ENVIRONMENTAL ASSESSMENT OF THE PROPOSED CRRRC

Response to Wallach - Critical Review of Geoscientific Component of TMES EA Final Version, February 2, 2015

Report Number: 12-1125-0045/13000

FIGURE 3-7

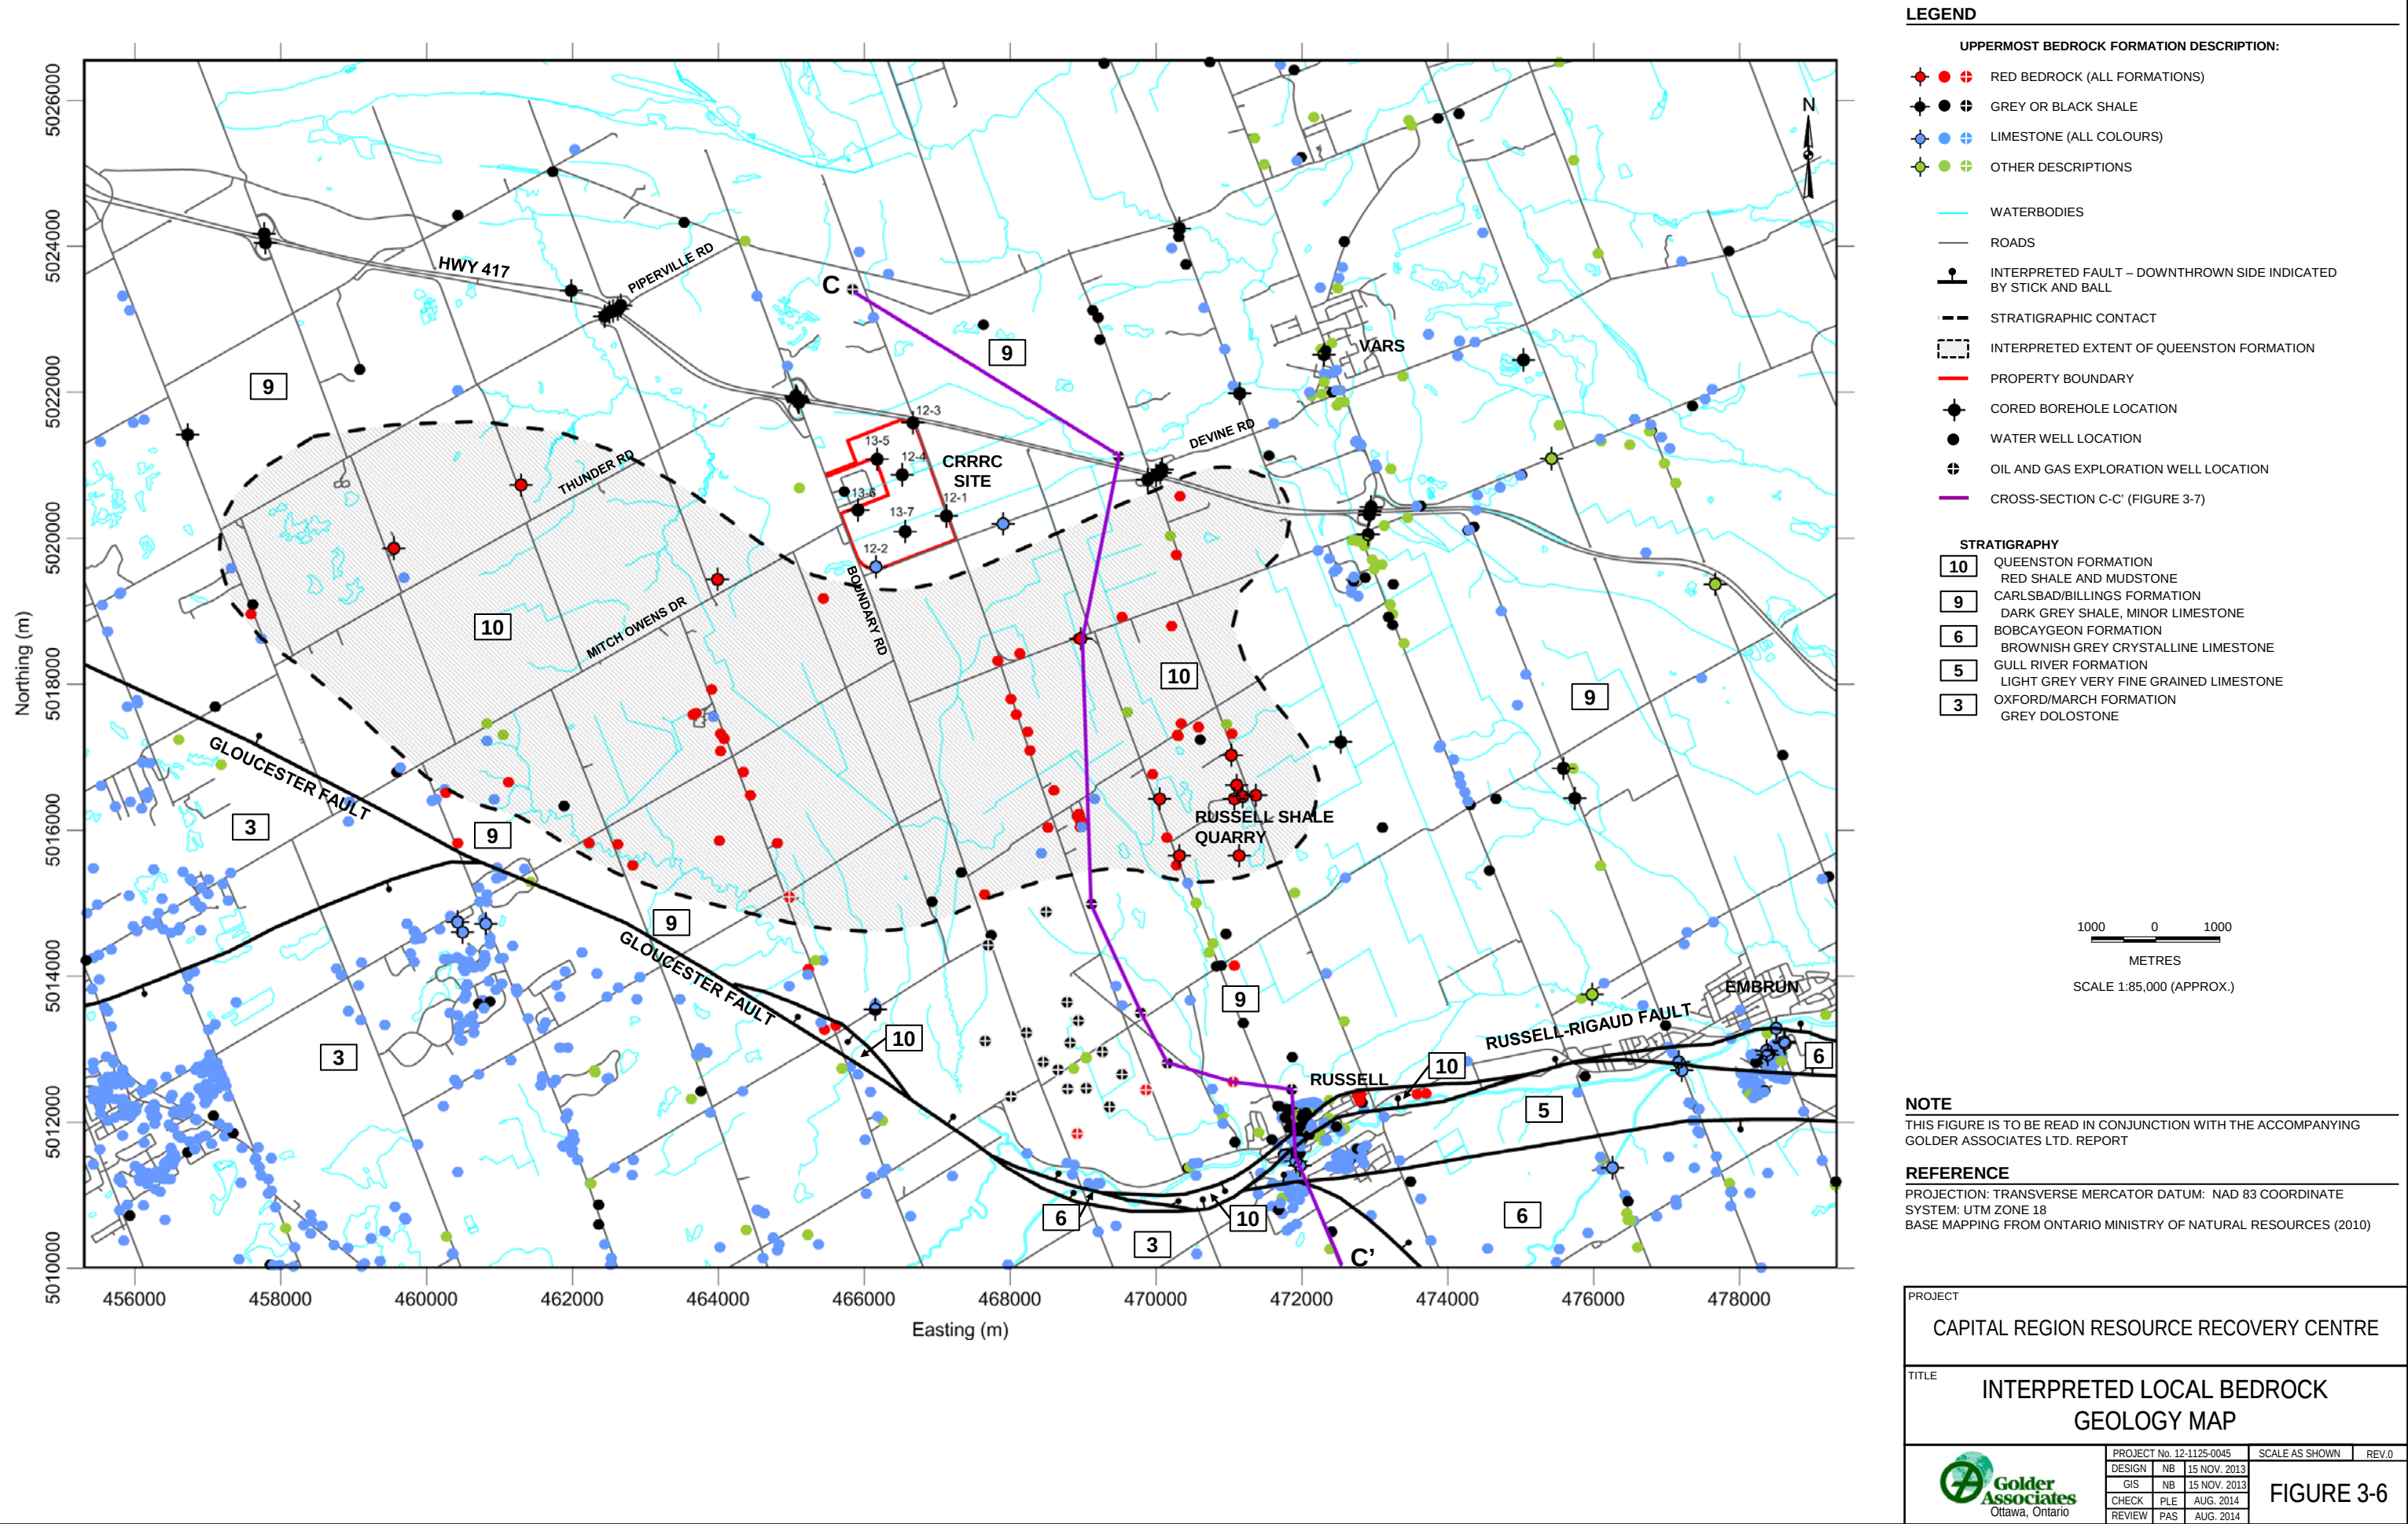
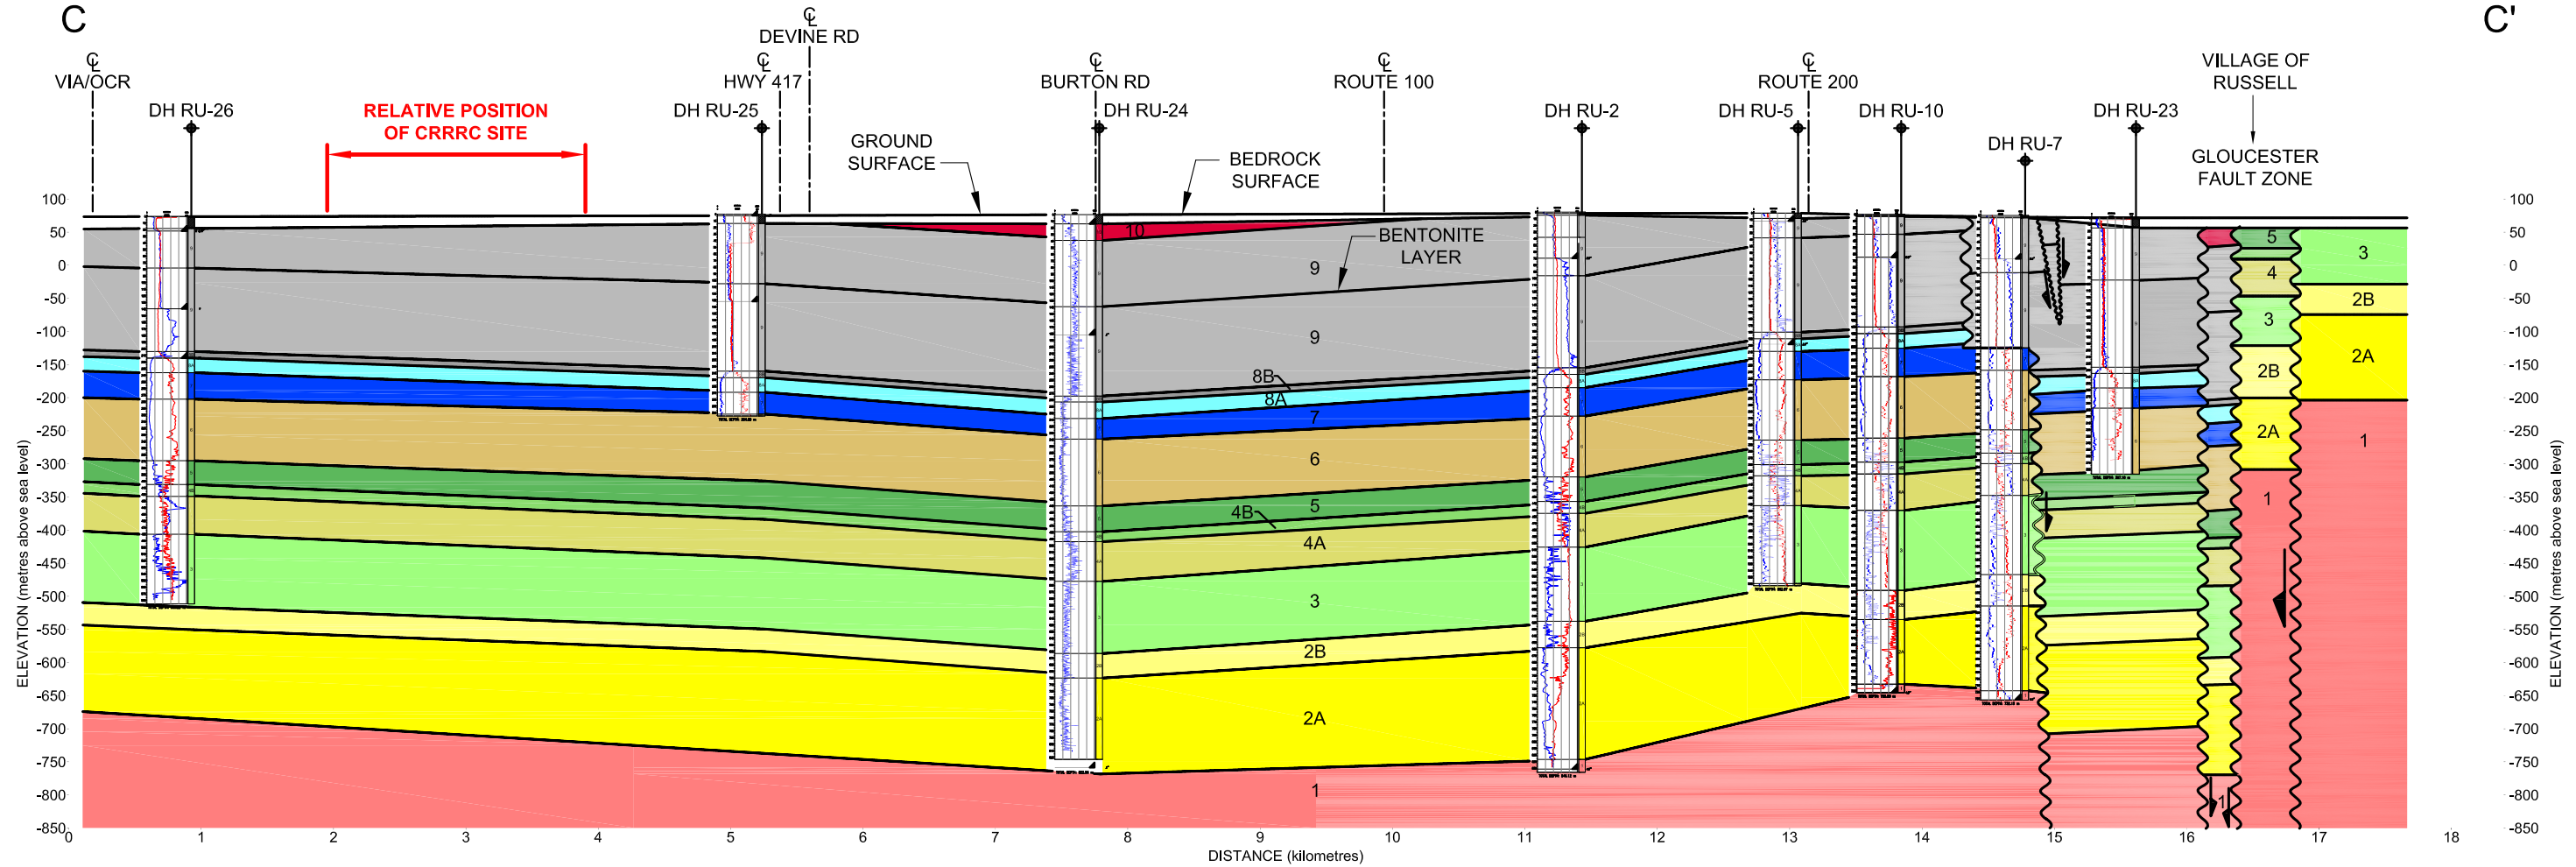
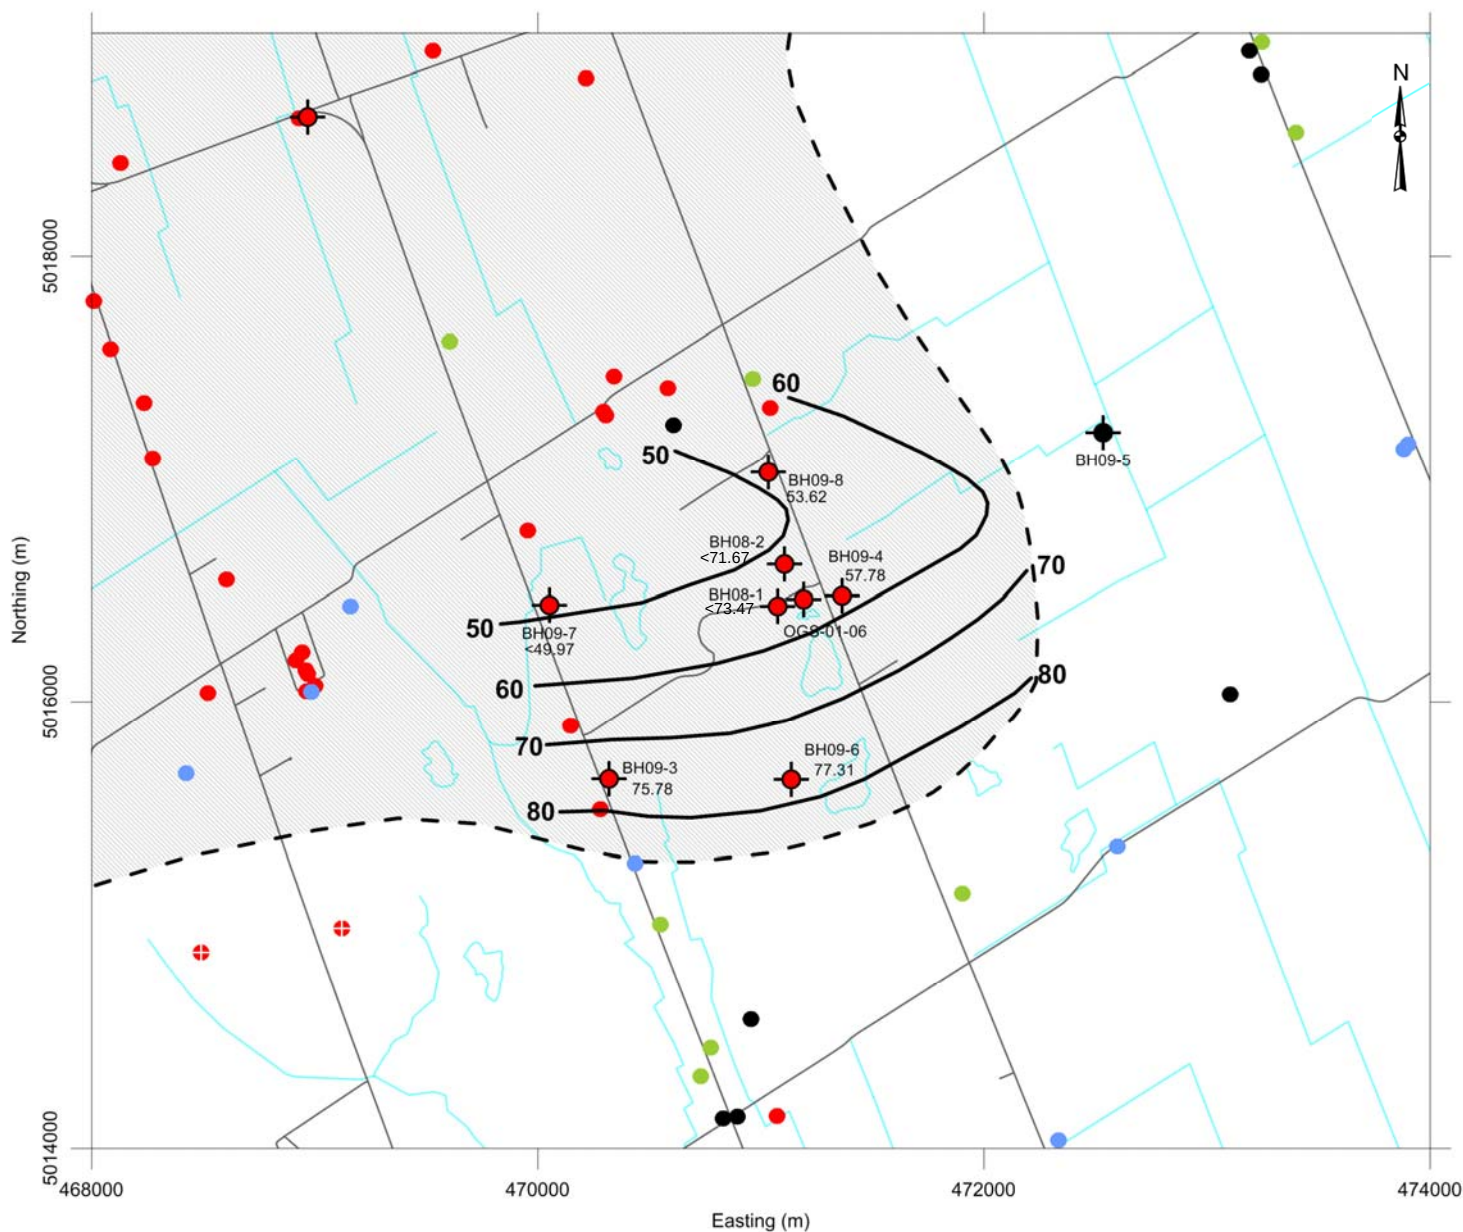
A second example relates to the plan and cross-sections provided in Wallach (2014) (Figures 14 through 16), some information from which is included on Figures 9 and 11 of Wallach (2015) Section C Letter #1. By matching the MOECC WWIS well location accuracy codes to the data points illustrated on these figures (as described above), we determined that eight of the 29 control point locations (28%) used to generate the sections were derived from MOECC WWIS data with an accuracy code of 9, and one point was derived from data with an accuracy code of 5. To illustrate, as shown on Wallach (2014) cross-section C-D on Figure 15, bedrock elevation offsets are interpreted in the central portion of the figure based on limestone located east of the supposed North Russell fault (NRF). The data point that shows limestone was matched to MOECC WWIS Well ID # 5603497 that has a location accuracy code of 9. A review of the well record indicates that the well is located adjacent to County Road 3, in Russell, Ontario about 5.5 km south of its location shown on Wallach (2014) figures. With this well record removed from the section, no subsurface information exists to support the interpreted faults illustrated on Wallach (2014) Figure 15. The cross-sections on Figure 16 were similarly created using "code 9" data; again, with those wells removed no information exists to suggest the interpreted East Ridge fault on Figure 16. There is no available subsurface information suggesting the presence of the North Russell and East Ridge faults interpreted and named by Dr. Wallach. As described later in this Section and in Section 2.1.5, the results of drilling investigations at the North Russell Road Site (the quarry site) demonstrate that the bedrock ridge is continuously underlain by Queenston shale bedrock and the limestone inferred by Dr. Wallach to exist near surface within the ridge associated with the presence of his inferred North Russell and East Ridge faults is not present.

Wallach (2014) used data from the Ontario Oil, Gas and Salt Resources Library (OOGSRL) to develop his geological model of his study area. The well cards from the OOGSRL include the elevations of geological formations encountered during drilling, which Wallach (2014) used as the primary data source for interpretation of the elevation of the top surface of the Carlsbad Formation. We assume that by “top surface”, Wallach (2014) is referring to the Queenston Formation/Carlsbad Formation contact. Although the data included in the OOGSRL records are in general more reliable and of higher quality than the MOECC WWIS data, a detailed review of these data is necessary before extrapolating them into geological models. As part of the CRRRC studies, we carried out an extensive review of the OOGSRL records including the acquisition of the digital files for the 26 available individual borehole geophysical records. We completed a detailed stratigraphic interpretation of these geophysical records.

We also examined the rock core from the GSC Russell borehole (RU-24, OOGSRL well card T002252) stored at the Tunney’s Pasture core library. The well card for RU-24 reports the Queenston/Carlsbad Formation contact at a depth of 39 m. Examination of the actual rock core shows the contact is at 26.8 m, where it has also been labelled in the core box by others. This contact depth also coincides with the borehole geophysical signature and further demonstrates the need to verify contact horizons reported by the OOGSRL well cards. Detailed examination and interpretation of the borehole geophysical records is necessary because the well card information cannot be accepted at face value. Following our core log review, it was clear that of the 26 gas wells
